17 October 2024

RE: Exhibition of Amended State Significant Development Application – Proposed Minarah College, Catherine Field (SSD 30759158)

**PROPERTY: 268-278 Catherine Fields Road, Catherine Field
Lots 11 & 12 in DP 833983**

DRAWING TITLE				
DRAINAGE PLAN (ULTIMATE DEVELOPMENT)				
PROJECT NO.	PLANSET NO.	RELEASE NO.	DRAWING NO.	REVISION
P2108320	PS02	R03	PS02-E100	B

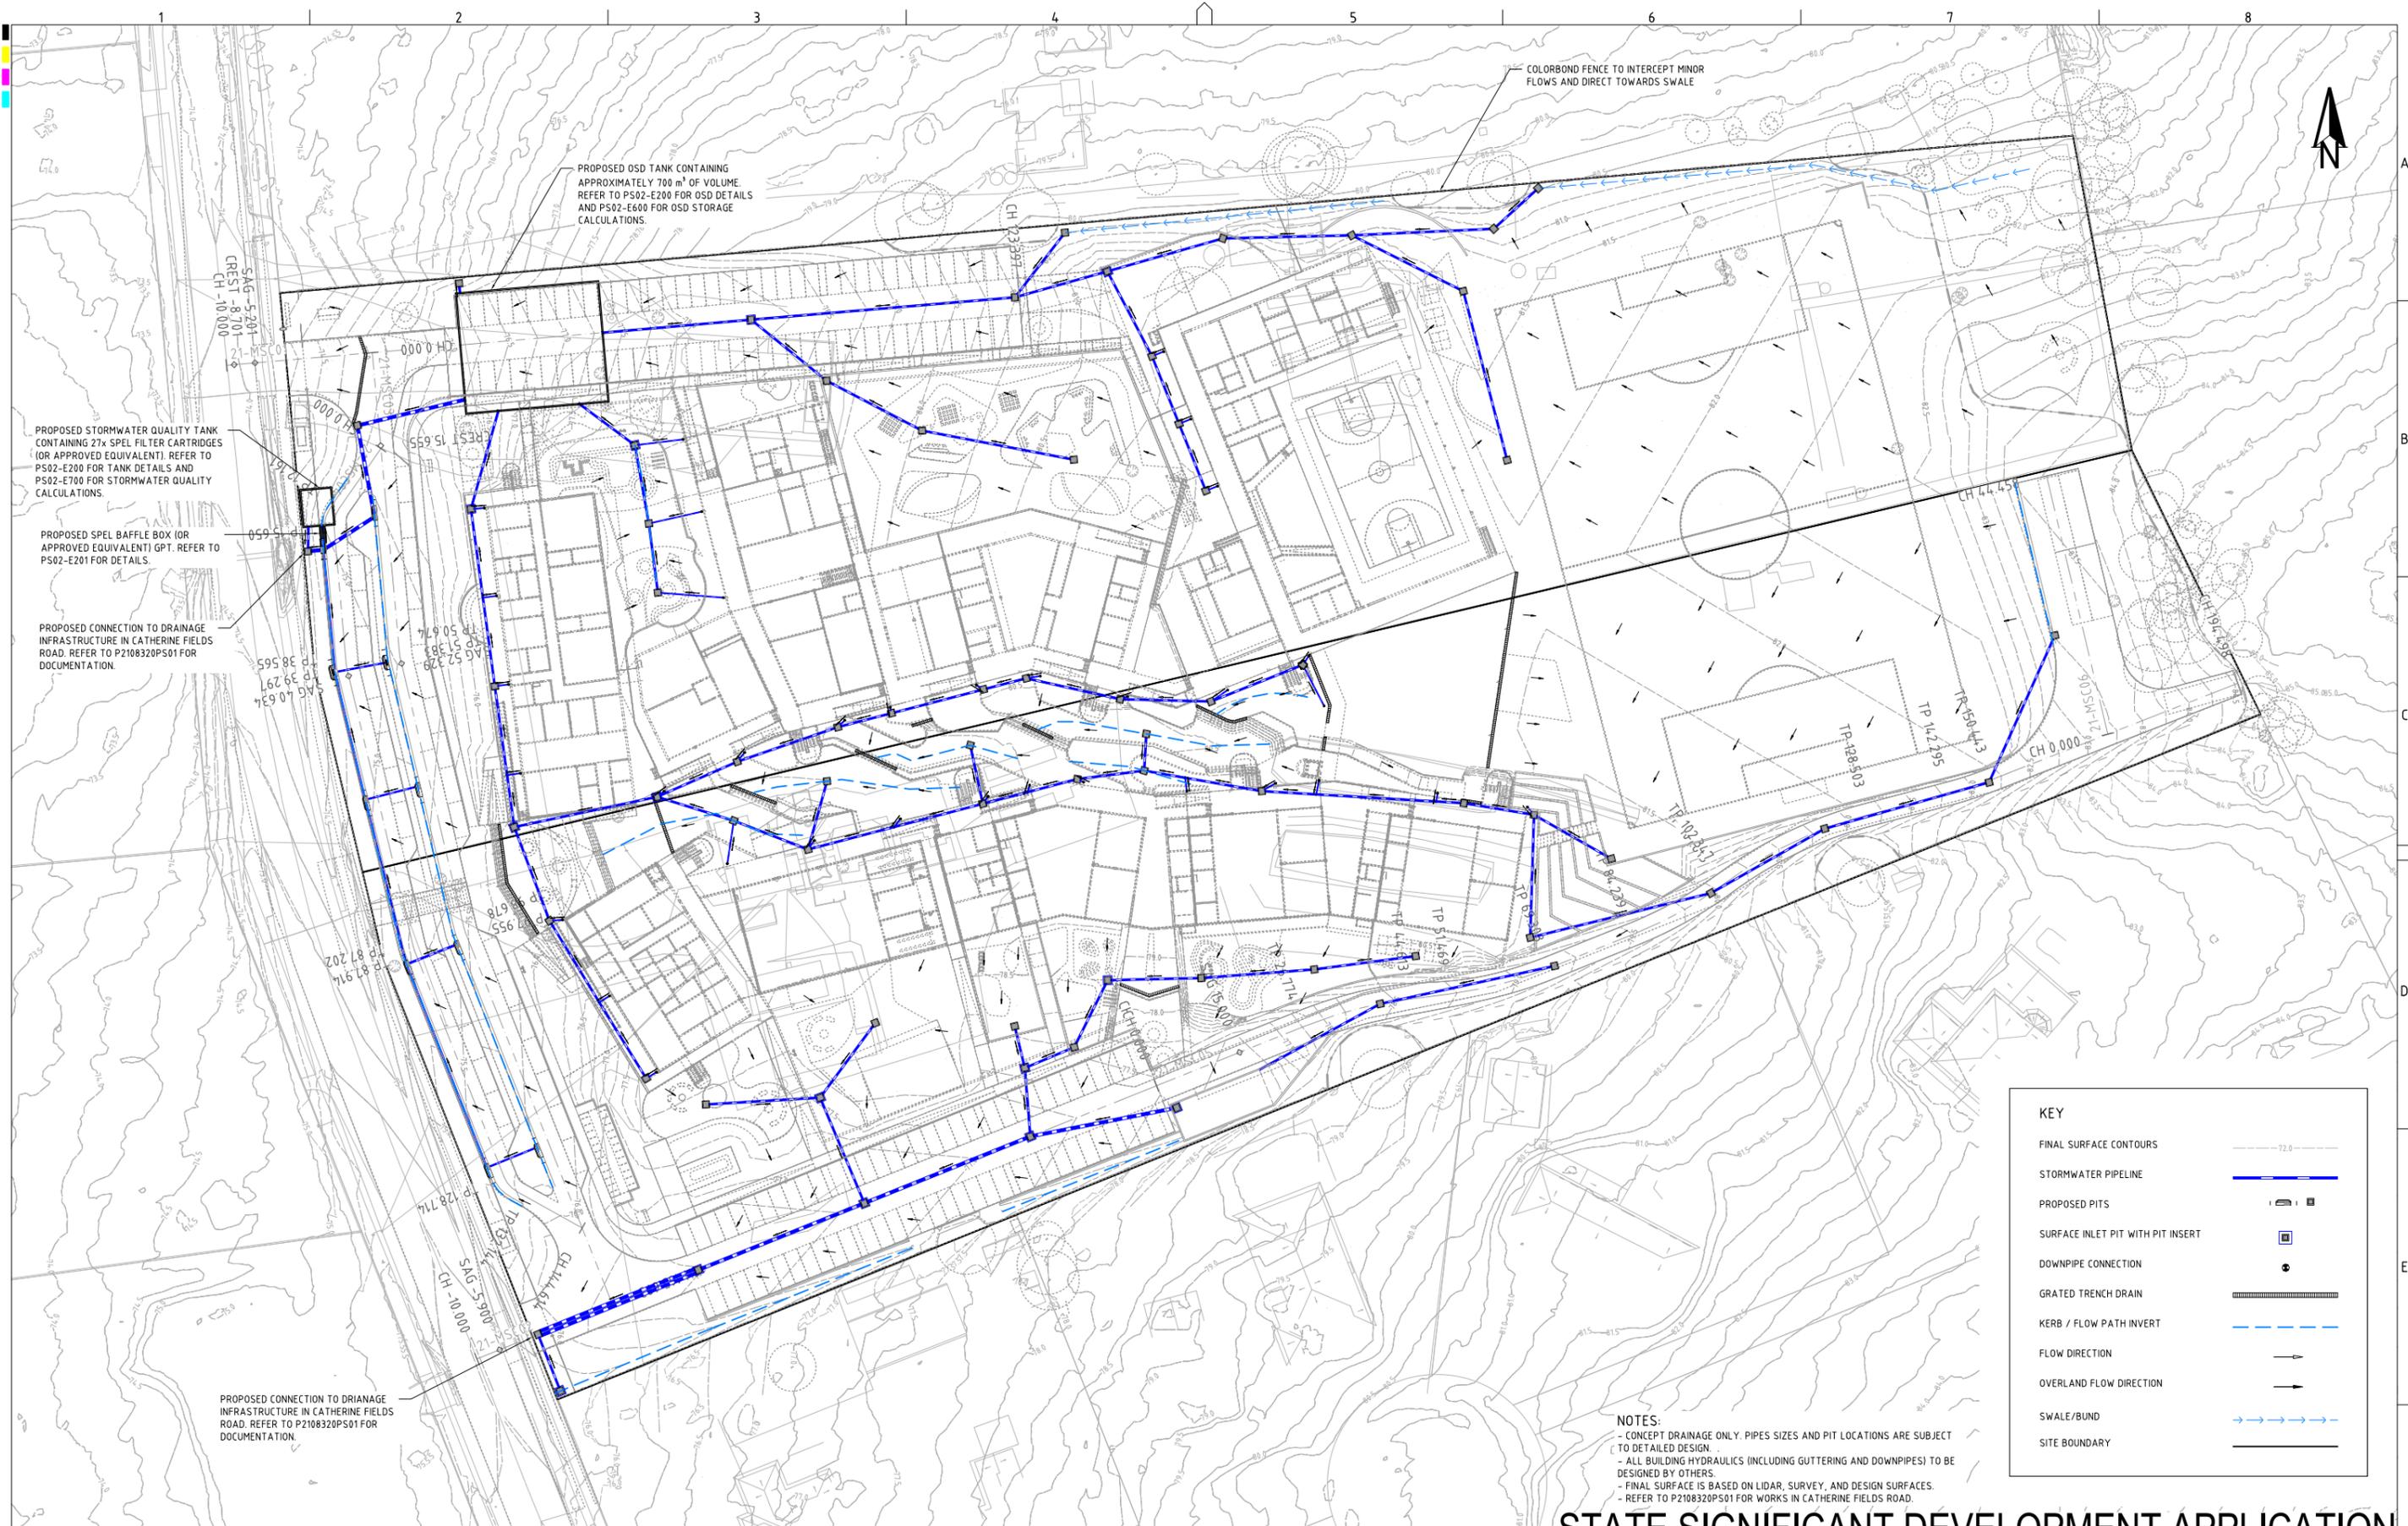
- The OSD has only catered for 60% impervious area. Any additional impervious area will require an updated and/or additional OSD system.
- The Catherine Fields Road long section shows road grades of as little as 0.3%. This is non-compliant and it is recommended that road grades are a minimum of 1%.

KERB RETURN (22-MRK05) LONG. SECTION (ON LIP)

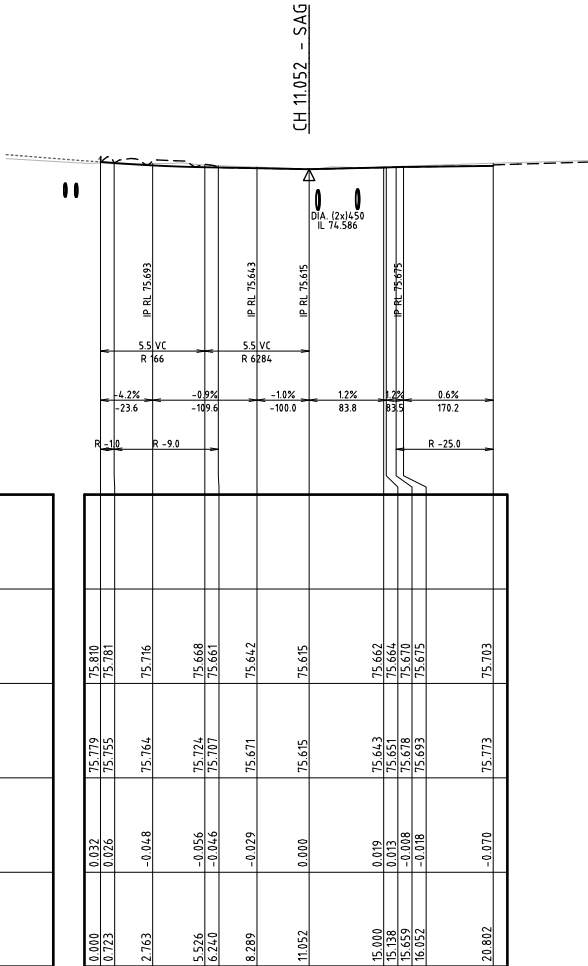
- Kerb return grades are noted as having a minimum of 0.3%. An absolute minimum of 0.7% is required under the Camden Council Engineering Design Specification.
